APPLICATION NO.	04DRB-00606	PROJECT NO.	1002777
PROJECT NAME	GARCIA REPLAT		
EPC APPLICATION NO.	—		
APPLICANT / AGENT	KAREN MARCOTTE	PHONE NO.	764-9801
ZONE ATLAS PAGE	G-13 <del>P&amp;S</del>		
(SDP for SUB), (SDP for BP), (FINAL PLATS), (MASTER DEV PLAN), (IR), (AA)			
<b>ONE STOP COMMENT FORM LOG</b>

Re: Project #1002777, Previous Vacation of Access Easement and Follow-Up  
Replat to Show Vacated Easement

**6. Project # 1002777**  
03DRB-01056 Major-Vacation of Public Easements

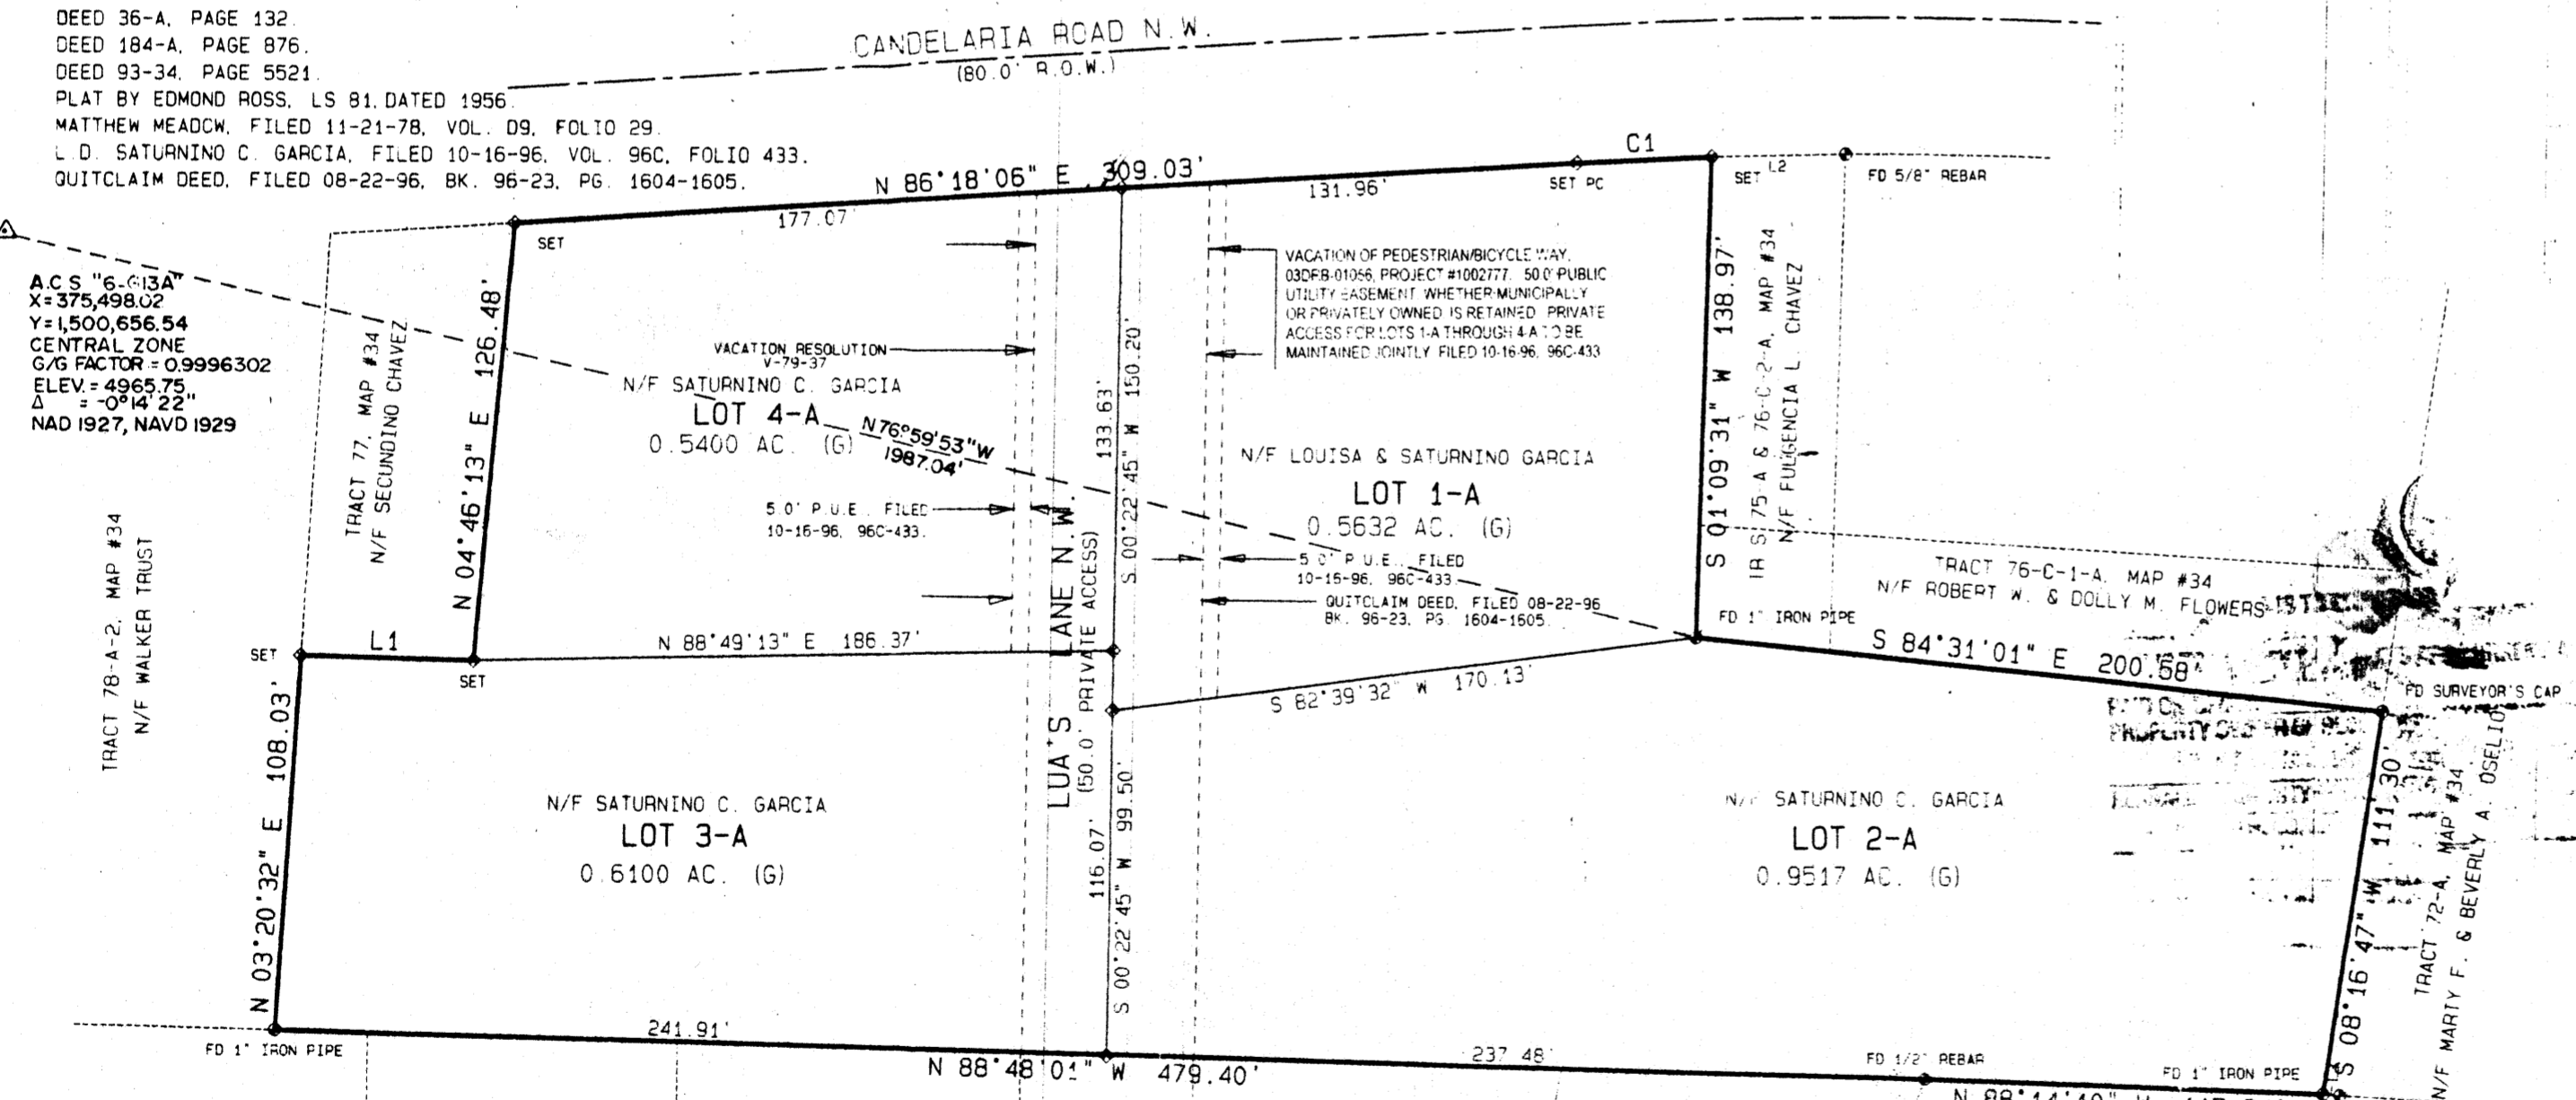
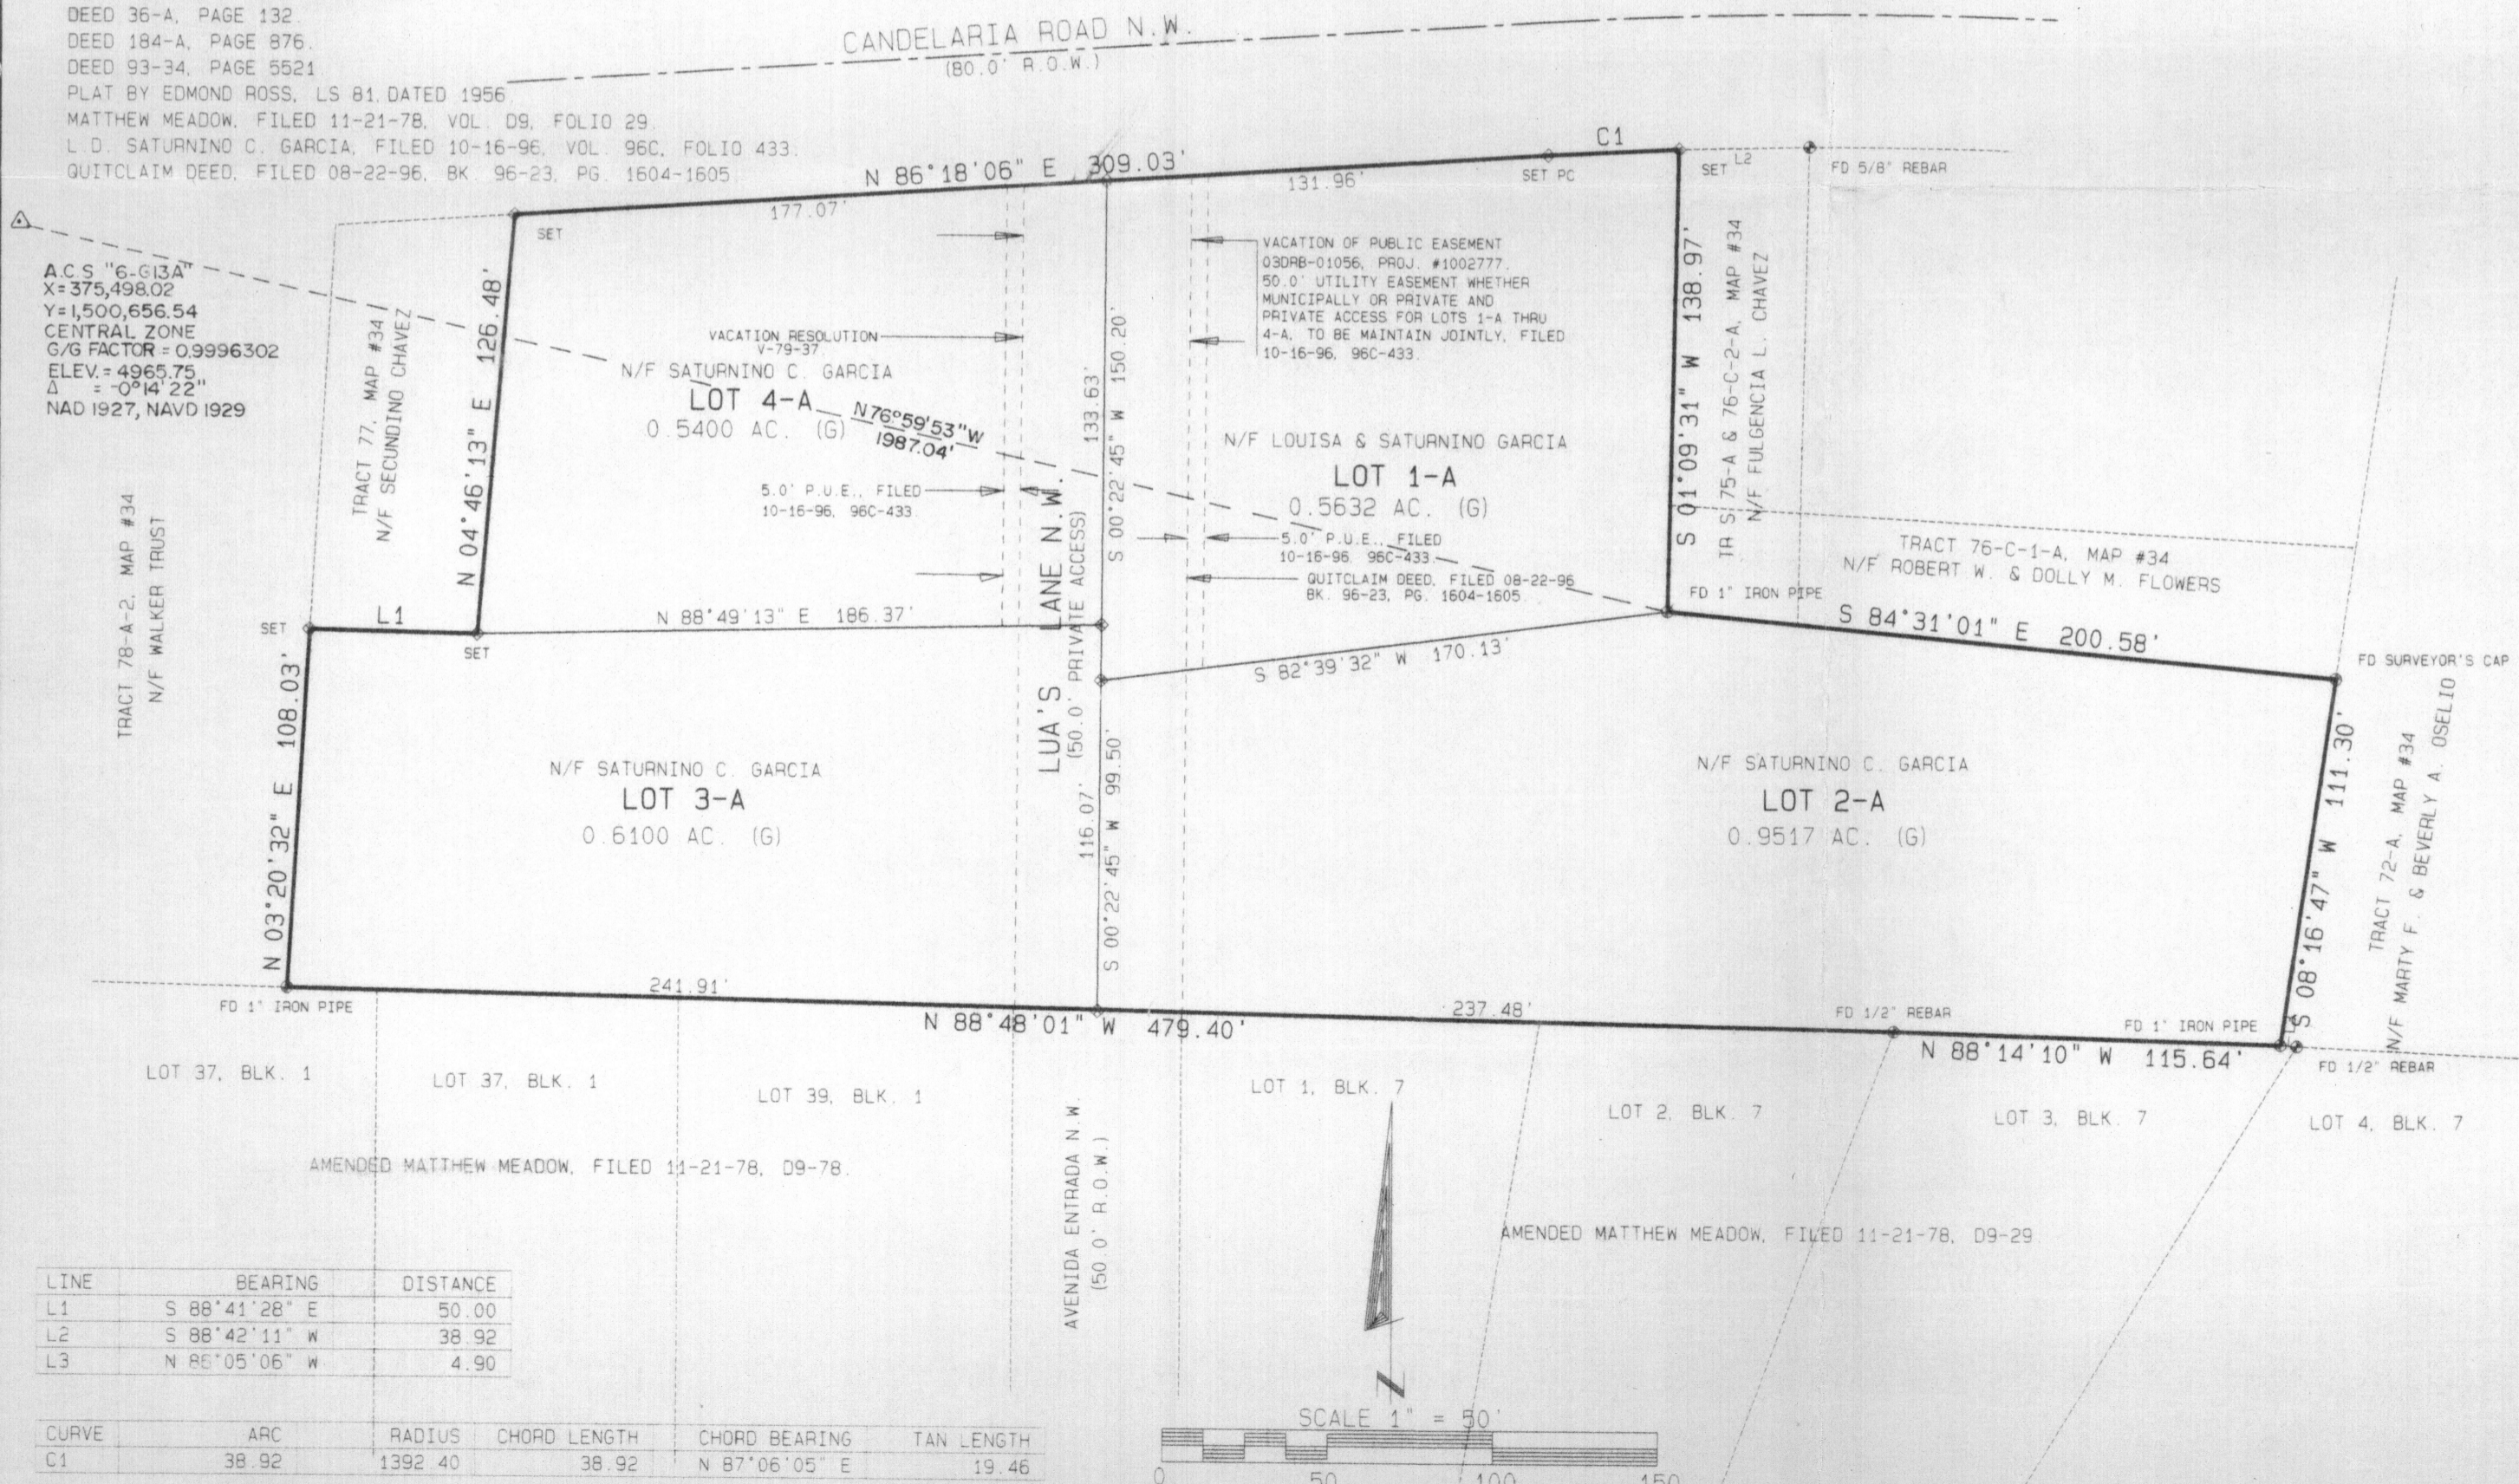
<b>UTILITY DEV (505) 924-3989</b>		
PLANS DISAPPROVED <i>bus</i>	DATE <i>4/21/04</i>	DATE
PLANS APPROVED <i>P&amp;S</i>	DATE <i>4/27/04</i>	DATE
COMMENTS:		
<i>Public Water Line Easement must be retained over the vacated 50' Easement. See Staff Report.</i>
